Laurie Leader - 131 Washington Avenue Plan Review Comments,

Please find my responses to your comments on drawings S-1 and S-2, regarding structural questions that you had.

Sheet No: **S-2**

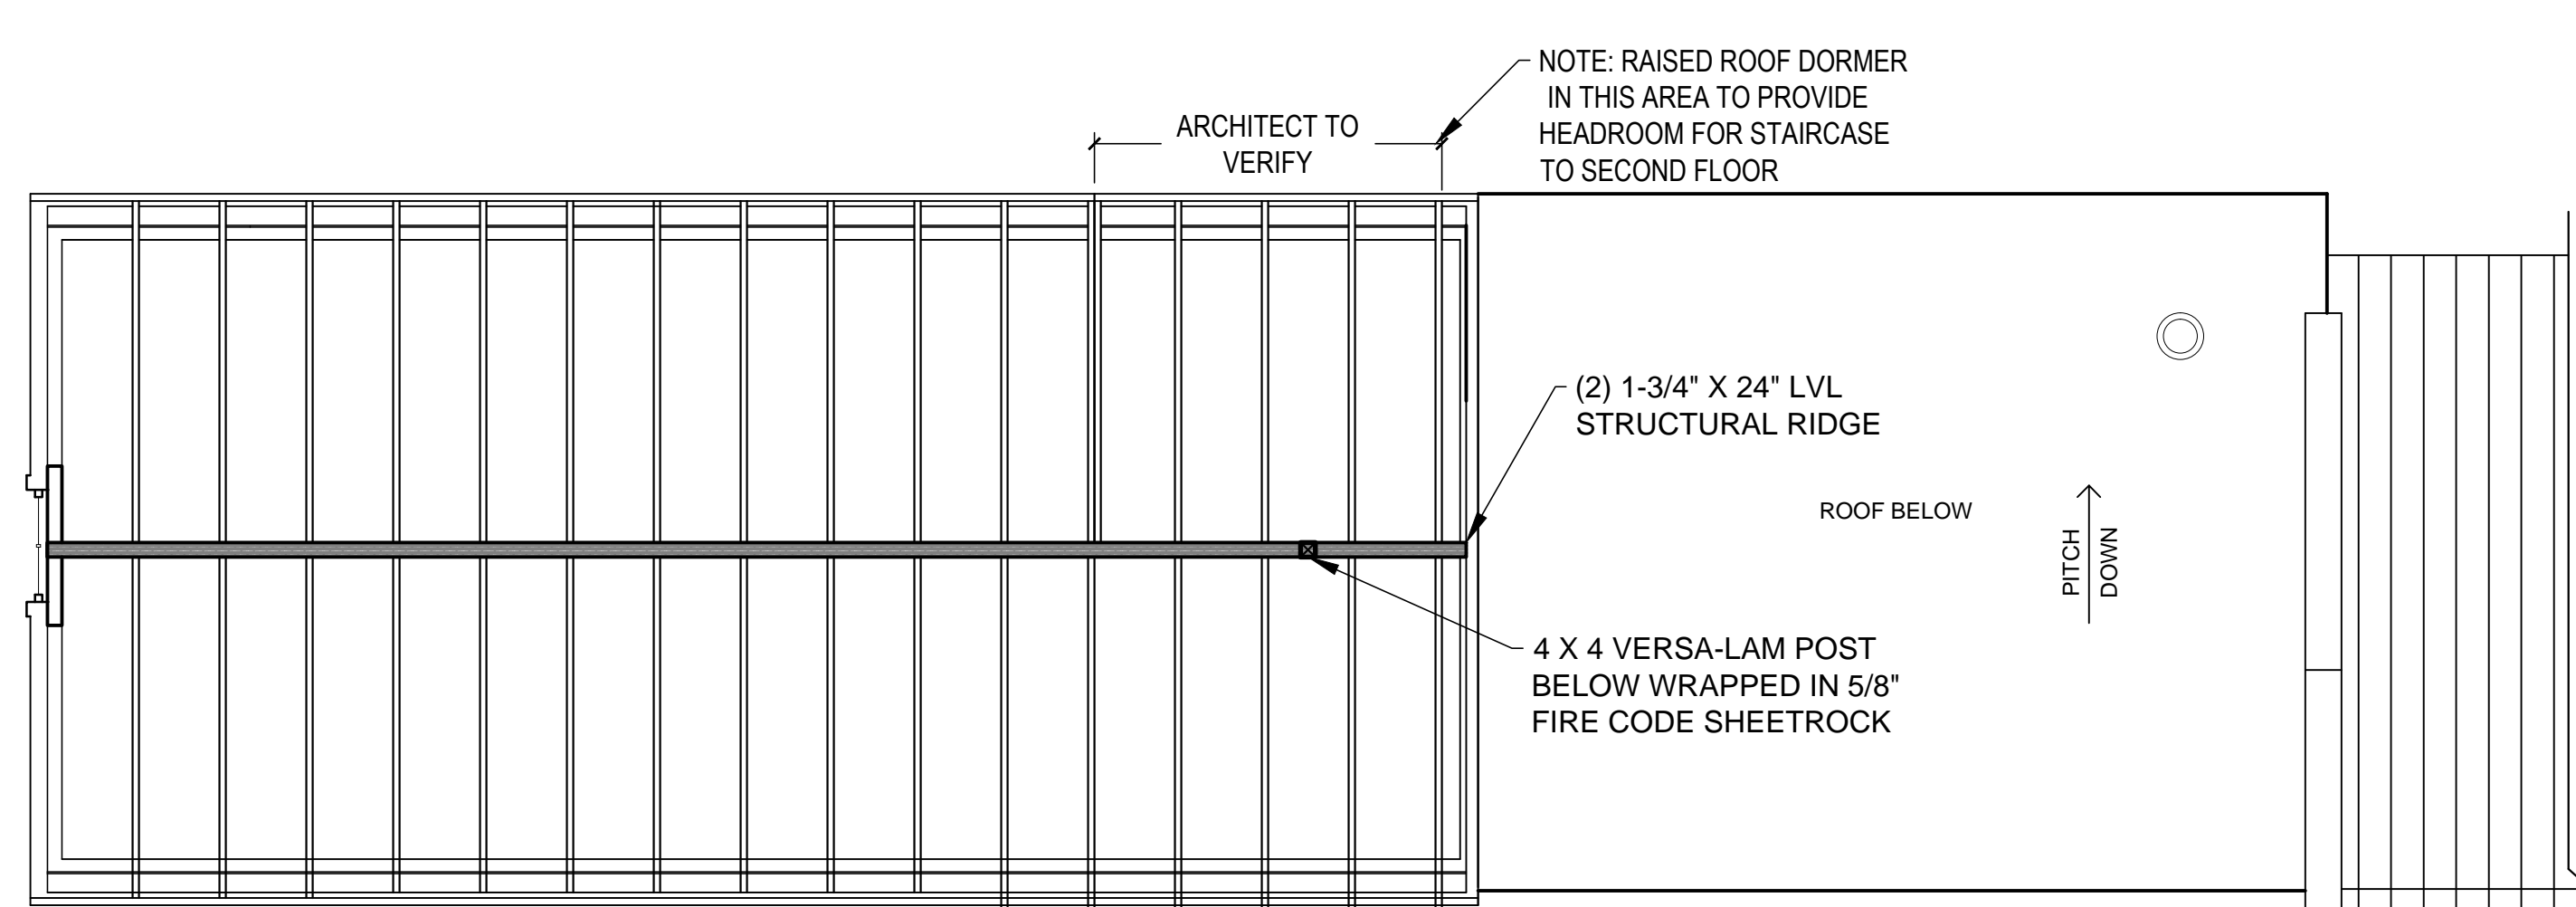
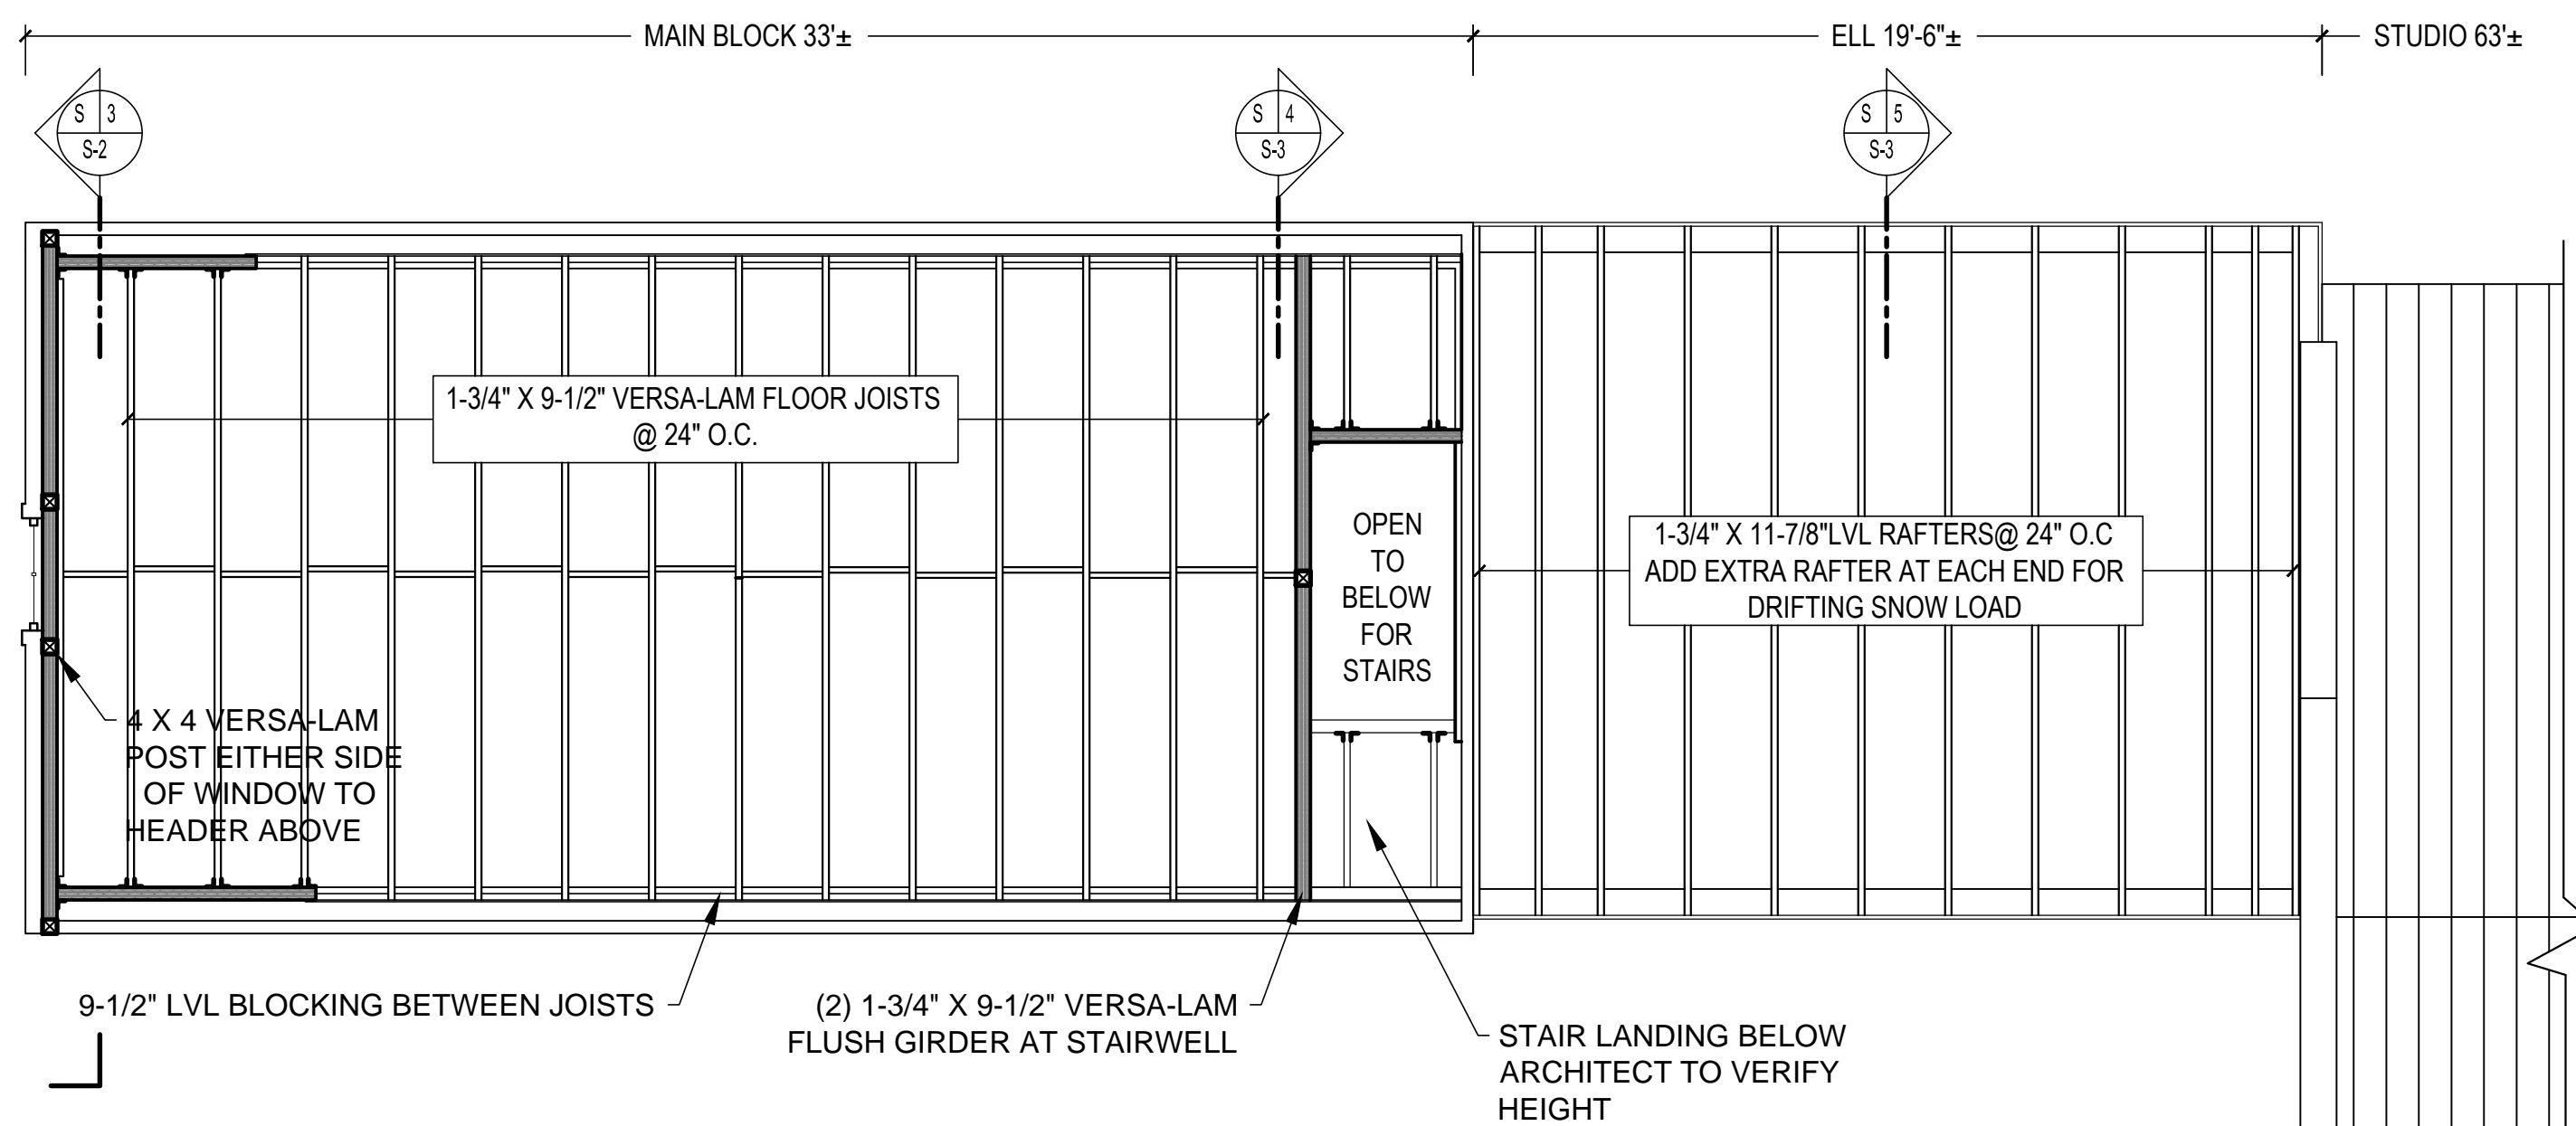
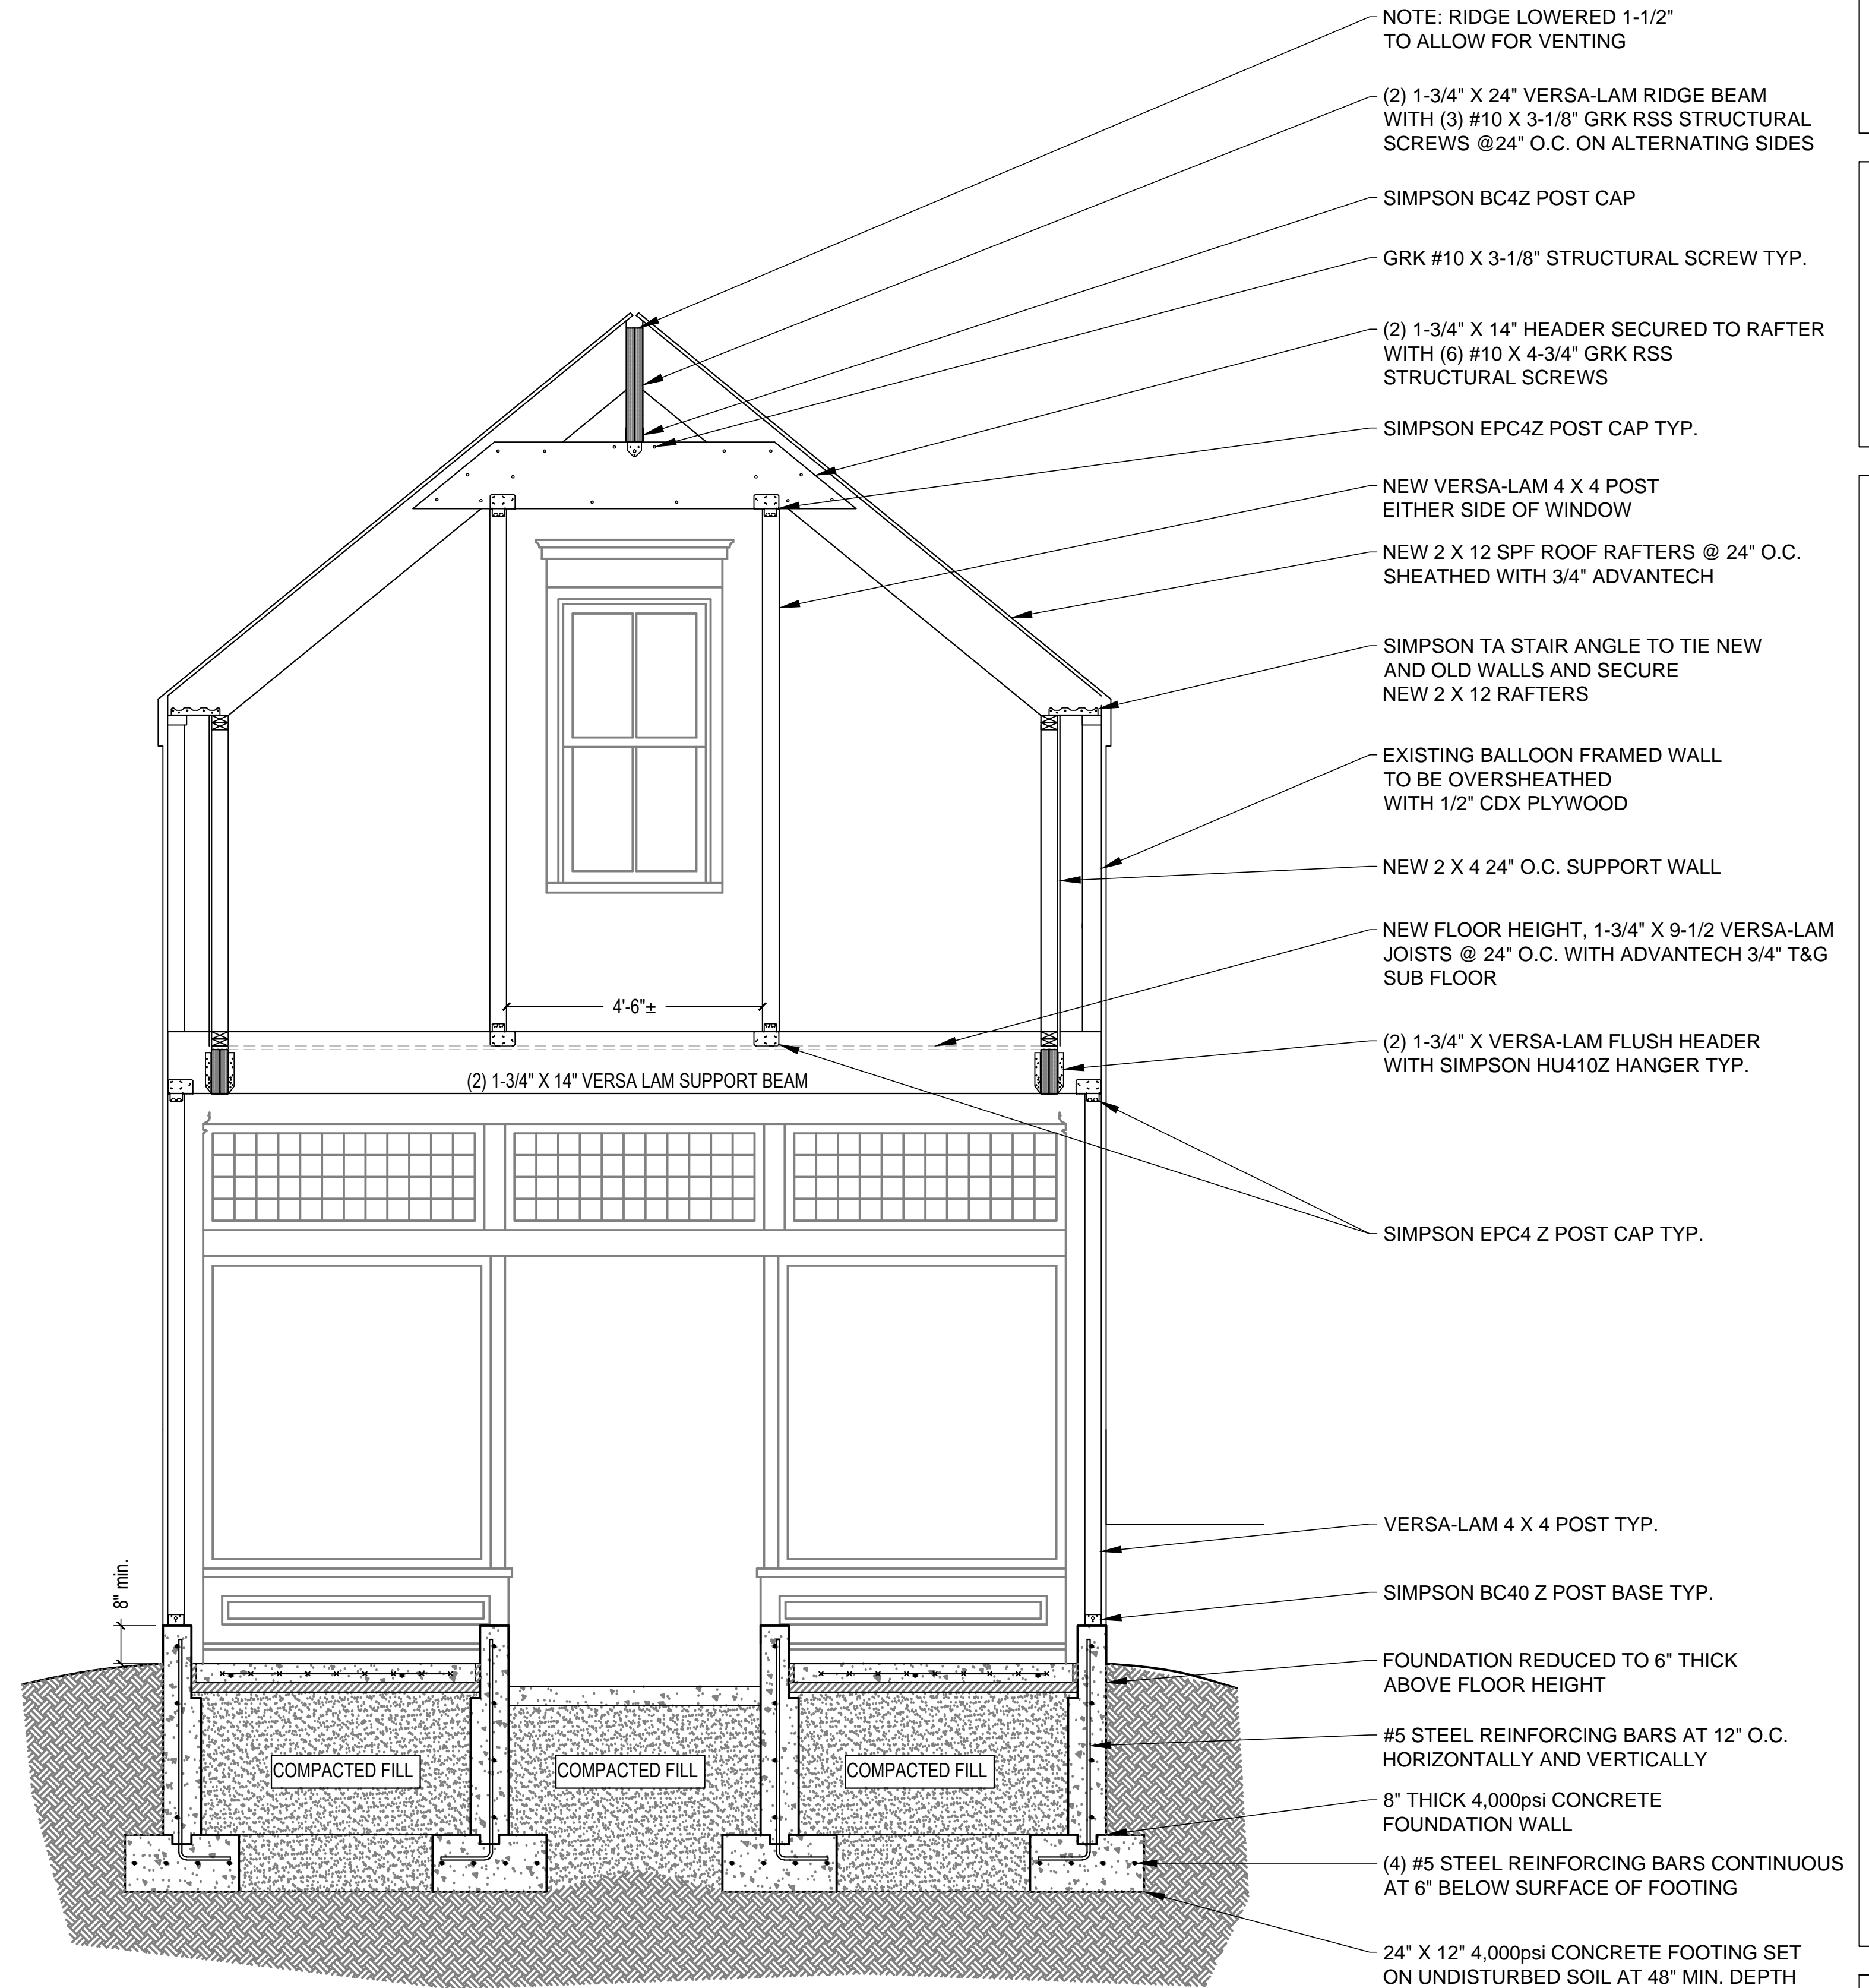
S-2 re: Specifications for LVL rafters and versa-lam floor joists: Those materials are specified on Sheet S-0, Structural Notes and Materials Specifications. Under the Note Section "Structural Lumber and Composite Wood Framing", please see note 2, which reads: "COMPOSITE LUMBER, WHERE INDICATED, SHALL BE VERSA-LAM, MANUFACTURED BY BOISE ENGINEERED WOOD PRODUCTS: BENDING STRESS $F_b = 3000$ PSI, ELASTIC MODULUS $E = 2000$ KSI".
